## **SANCROX QUARRY EXPANSION (SSD 7293) – RESPONSE TO FURTHER ADVICE FROM PORT MACQUARIE HASTINGS COUNCIL AND BIODIVERSITY AND CONSERVATION DIVISION**

We refer to your correspondence, dated 26 August 2021, requesting a response to the issues raised in the further advice provided by the Department's Biodiversity and Conservation Division (BCD) and Port Macquarie-Hastings Council (Council) in relation to the Response to Submissions (RTS) report for the proposed Sancrox Quarry Expansion Project (SSD-7293).

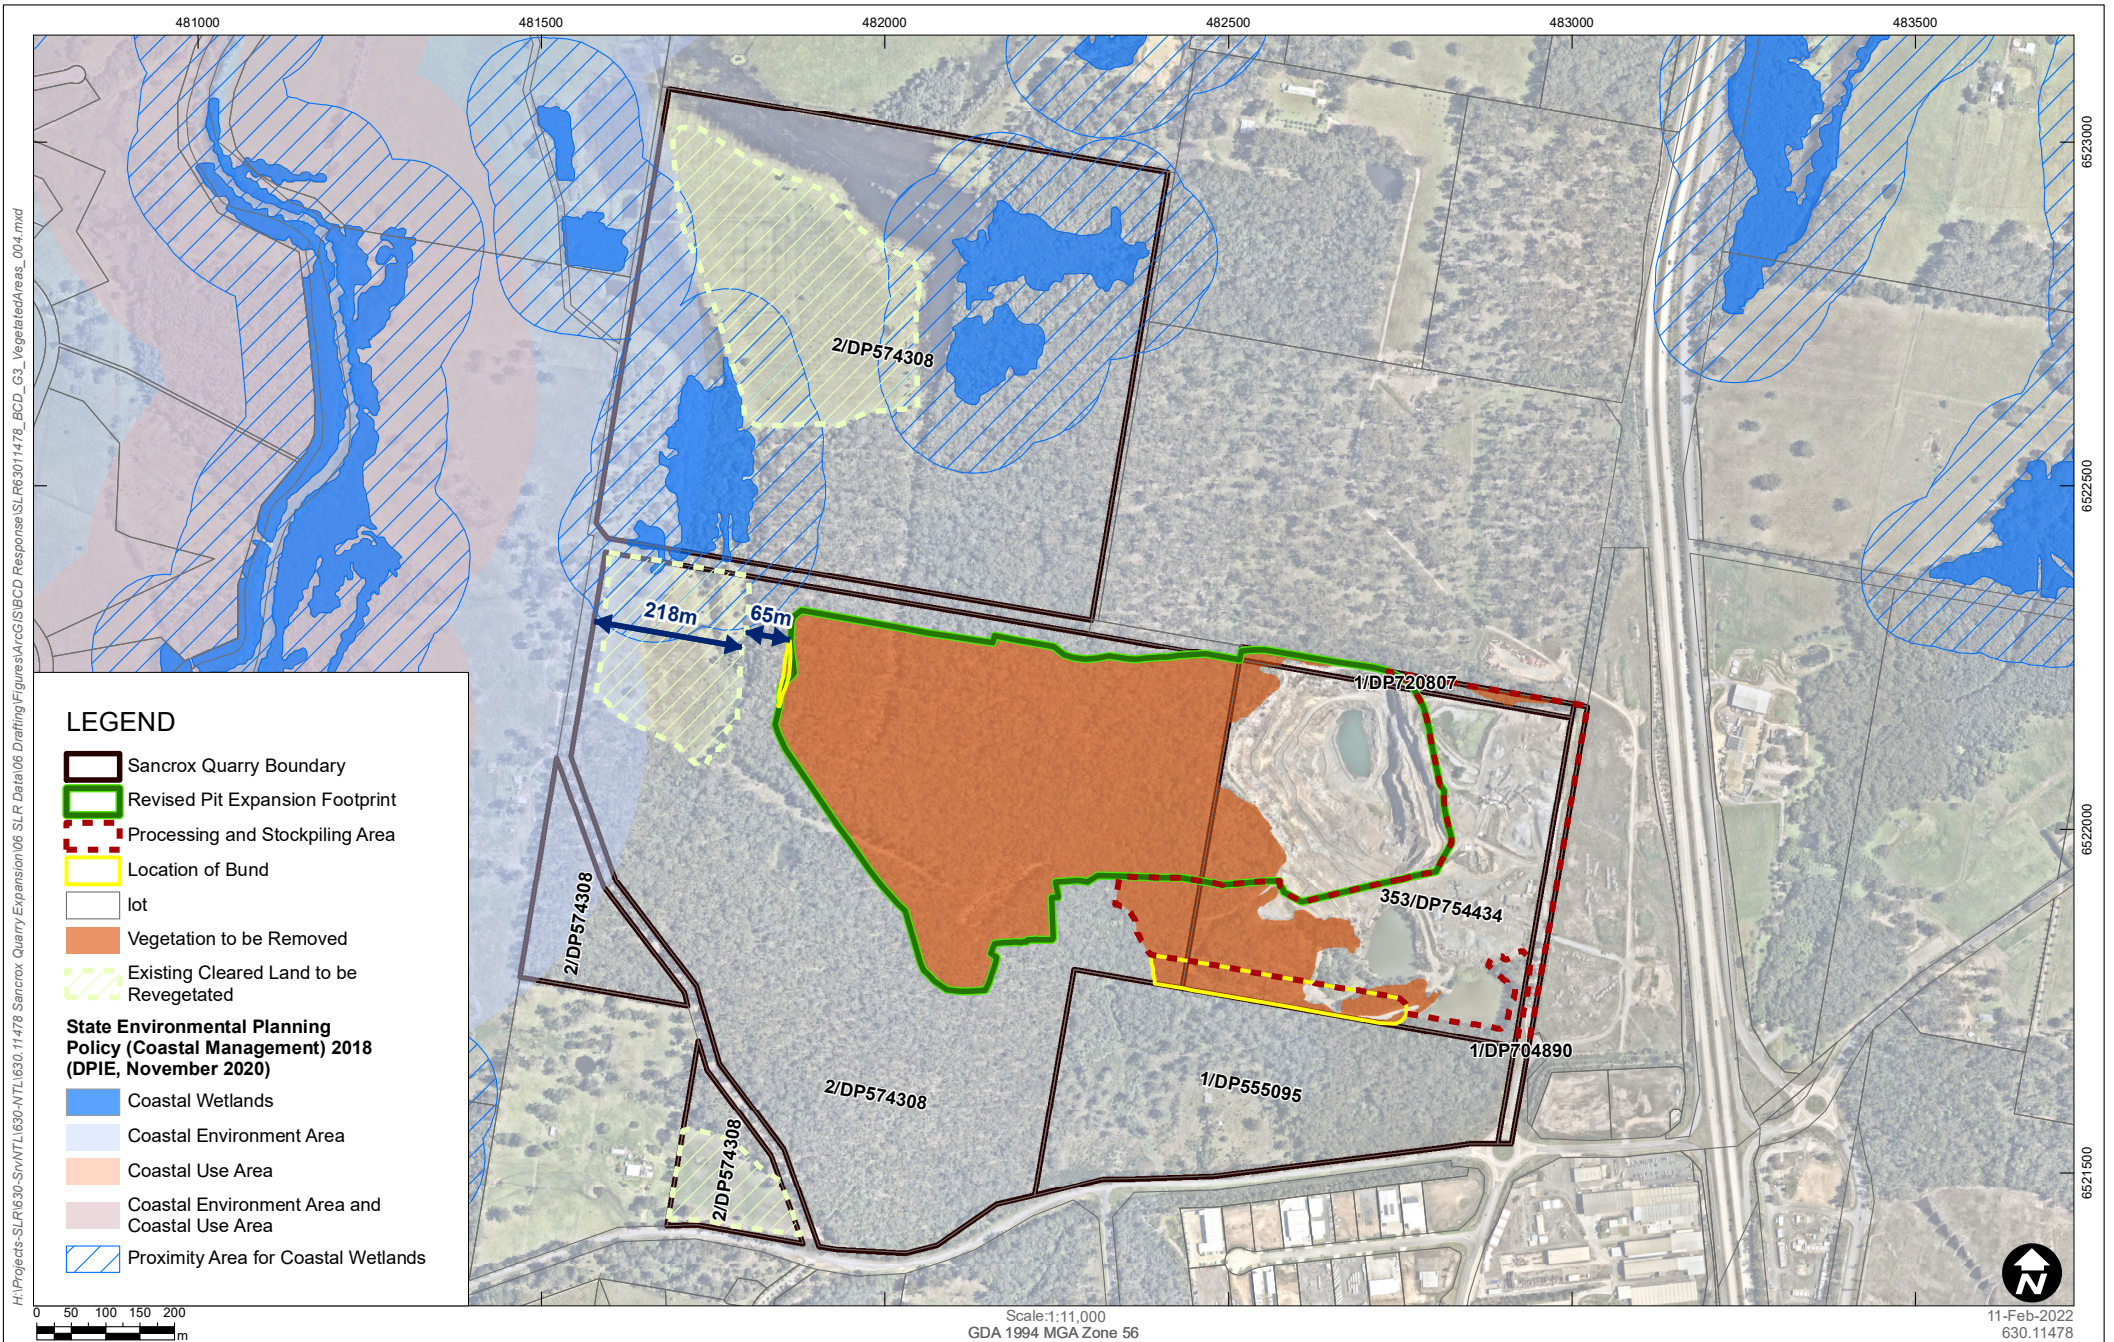
4. **“clearing of habitats and native vegetation will be offset through new planting and revegetation of an offset site of approximately 49ha”. However, there is no plan included that illustrates this. Given the area in question is already vegetated, demonstration of how this will be achieved is required.**

As part of the current response to the BCD submission on the RTS, additional areas are proposed for revegetation to the west of the proposed pit expansion area. The areas of cleared land proposed to be revegetated are shown in Figure 3 of Appendix C of the BAR Addendum report (**Attachment 1**). Around 17 ha of currently cleared land will be revegetated. The rest of the 49ha offset area will be subject of habitat improvements. Section 5.5 of the Revised BAR sets out the general strategies in relation to land rehabilitation and revegetation, and specifies that a Biodiversity Management Plan would be prepared. It is also highlighted that in order to generate any biodiversity offset credits, the offset site would be subject of a Stewardship Agreement under the *Biodiversity Conservation Act 2016*, which would document Hanson’s obligations in terms of conservation and improvement of biodiversity values at the offset site.
